## Appendix 9.1 Visual Impact Assessment Table

(Refer to Figure 8 for Viewpoint Locations)

Figure 5.3 Kingsland Indicative Masterplan

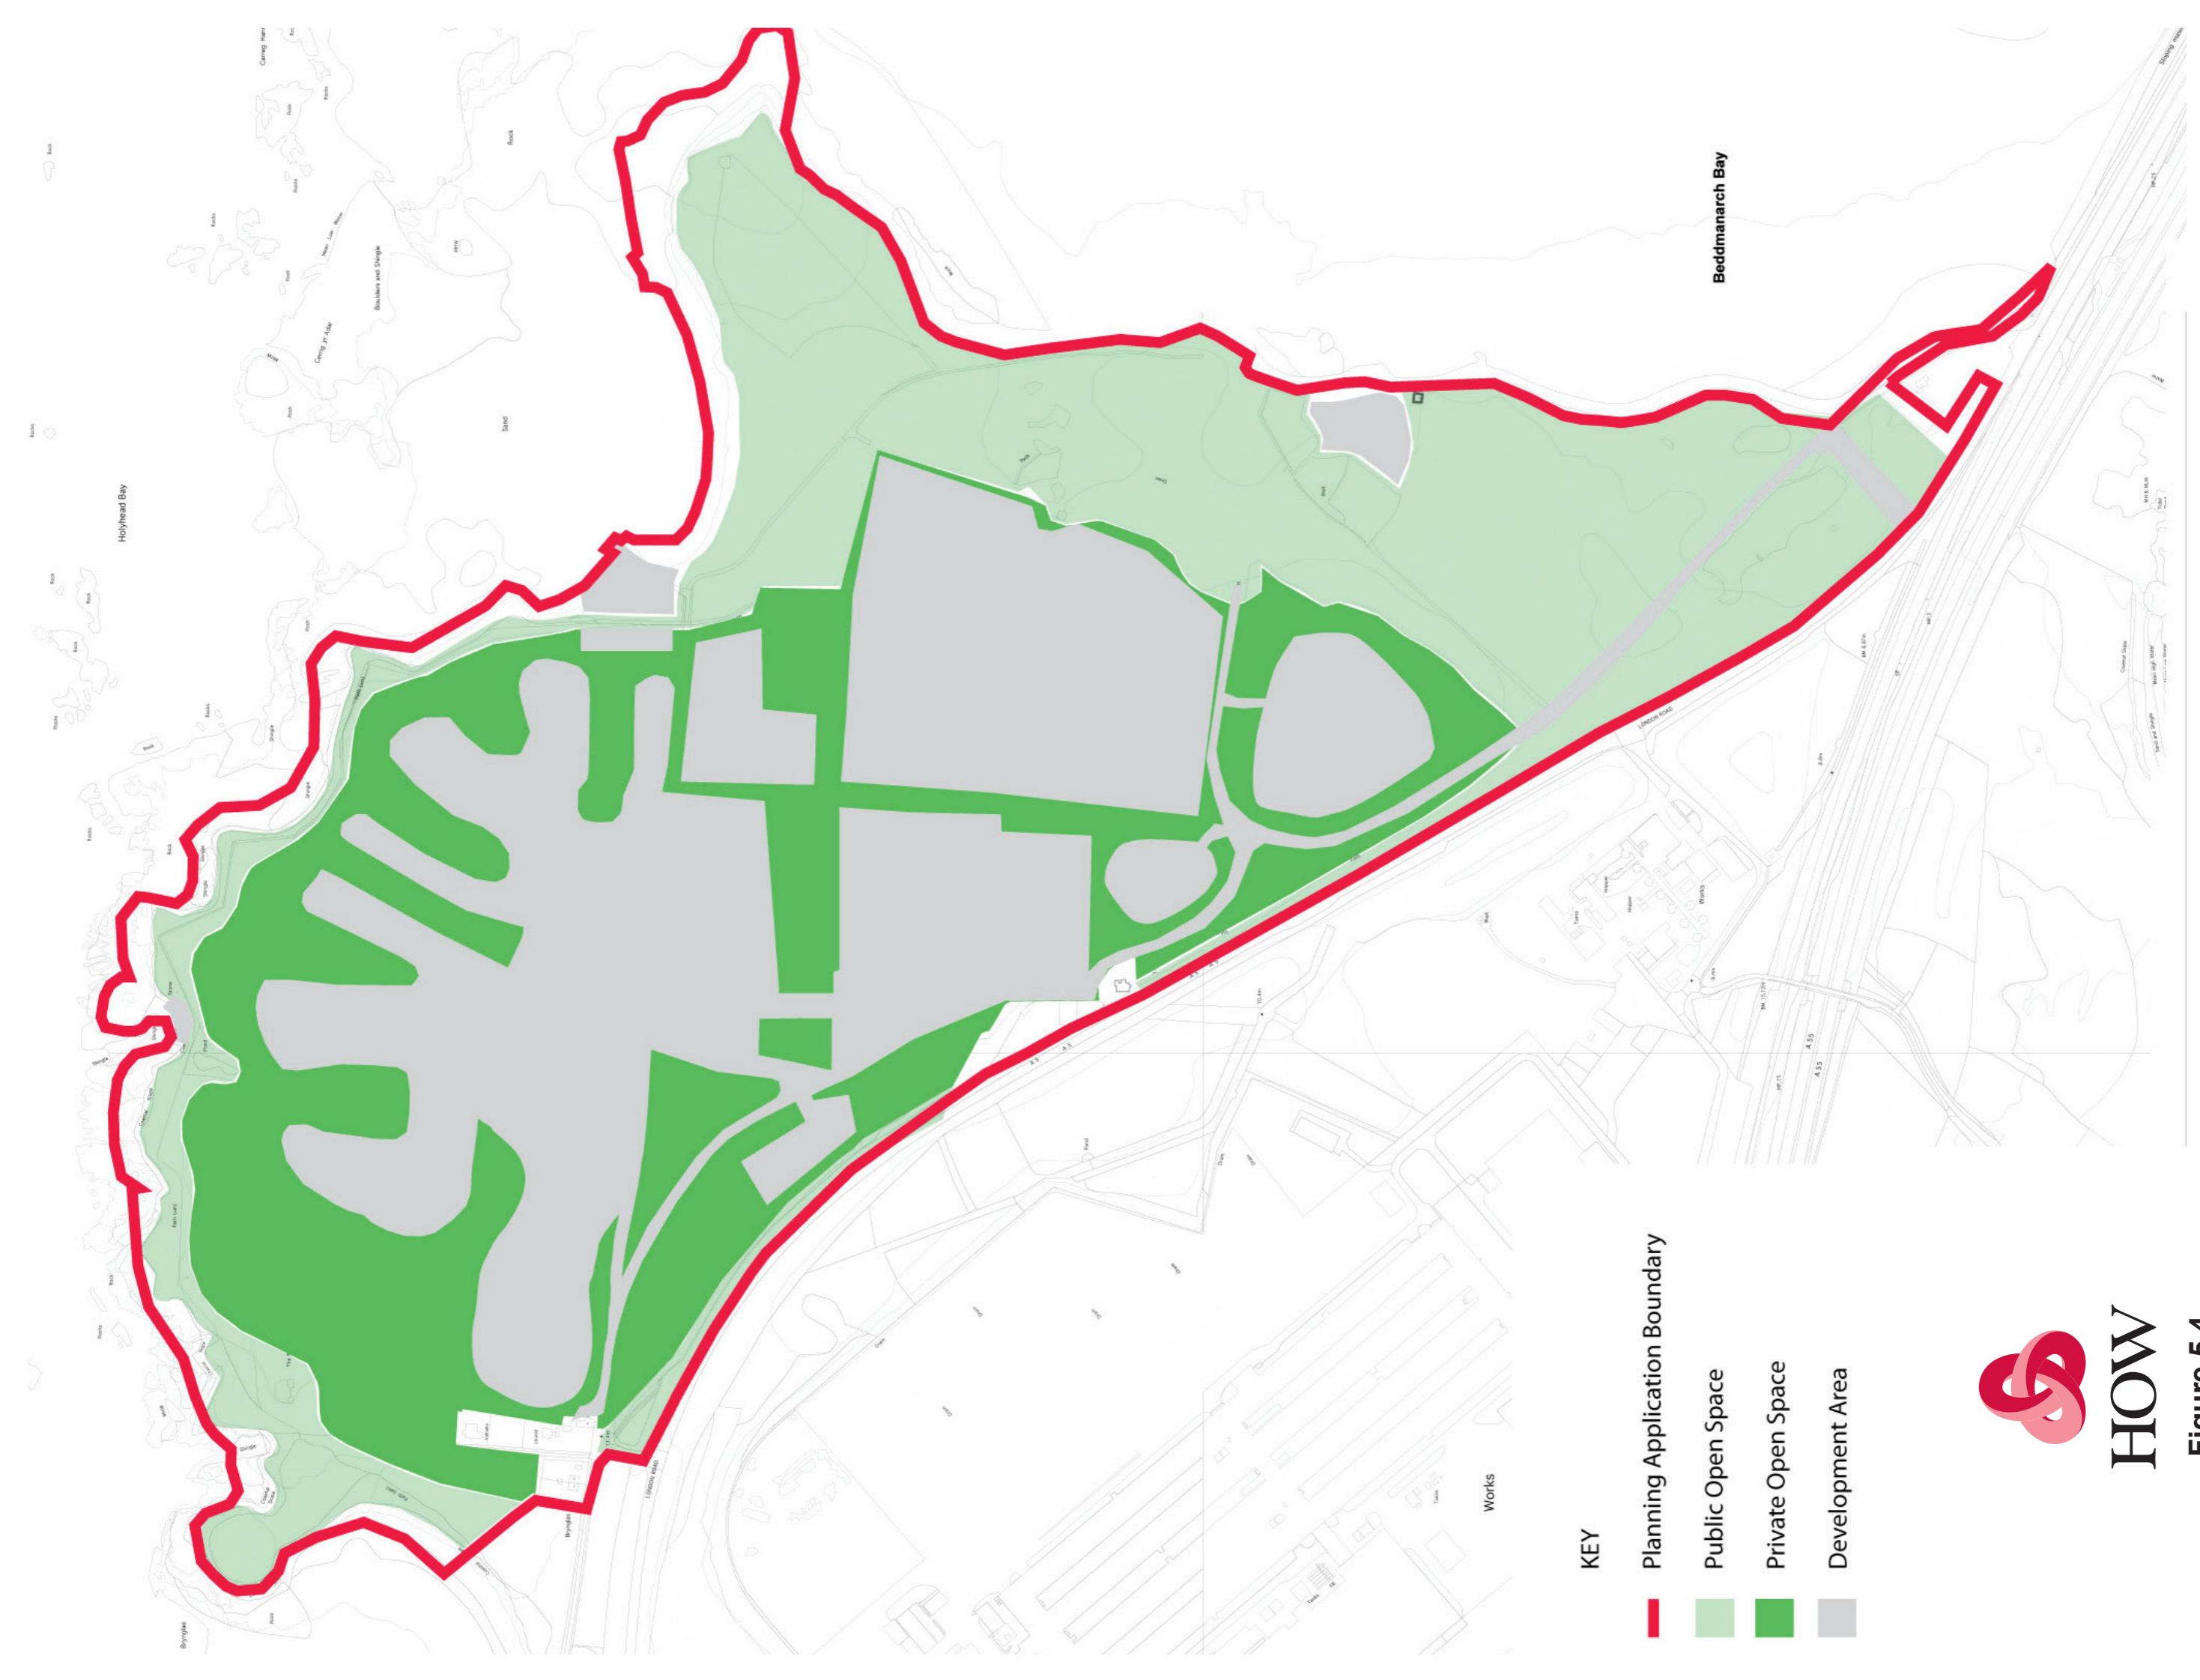
5 - 8						1	1	High	High	Moderate	Adverse	
		10+						1	2	High	High	Moderate	Adverse	
<b>KINGSLAND</b>														
5	View from Mill Road, to the north of the site, approximately 180 metres from the site boundary. <b>PHOTOMONTAGE VIEWPOINT</b>	1 - 3	High	x				3	3	High	Medium	Moderate	Adverse	Positive - High quality design and use of natural materials which reflect local character. Potential to further minimise impacts at the detailed design stage. A strong landscape framework will help to embed the development into the landscape. Negative - the character of the view will change from agricultural to more developed in nature, and long-range views will be blocked.
		5 - 8						3	3	High	Medium	Moderate	Adverse	
		10+						2	3	High	Medium	Minor	Adverse

5	View from Mill Road, to the north of the site, approximately 180 metres from the site boundary. <b>REVISED ASSESSMENT</b>	1 - 3	High	x	3	3	High	Medium	Major	Adverse	Revised from moderate adverse years 1-3 to major adverse, in order to acknowledge the significant impact. As part of the detailed design process there is significant potential for this impact to be reduced through indepth consideration of layout, scale and massing of the houses.
		5 - 8			3	3	High	Medium	Moderate	Adverse	
		10+			2	3	High	Medium	Minor	Adverse	
6	View from Mill Road, to the north of the site, at the junction with the public footpath, approximately 50 metres from the site boundary. <b>PHOTOMONTAGE VIEWPOINT</b>	1 - 3	High	x	1	1	Medium	High	Moderate	Adverse	Positive - Careful consideration of the edge of the proposed housing, and incorporation of green space and houses more rural in character help to minimise potential impacts. A strong landscape framework will help to embed the development into the landscape. Negative - the character of the view will change from agricultural to more developed in nature, and long-range views will be blocked.
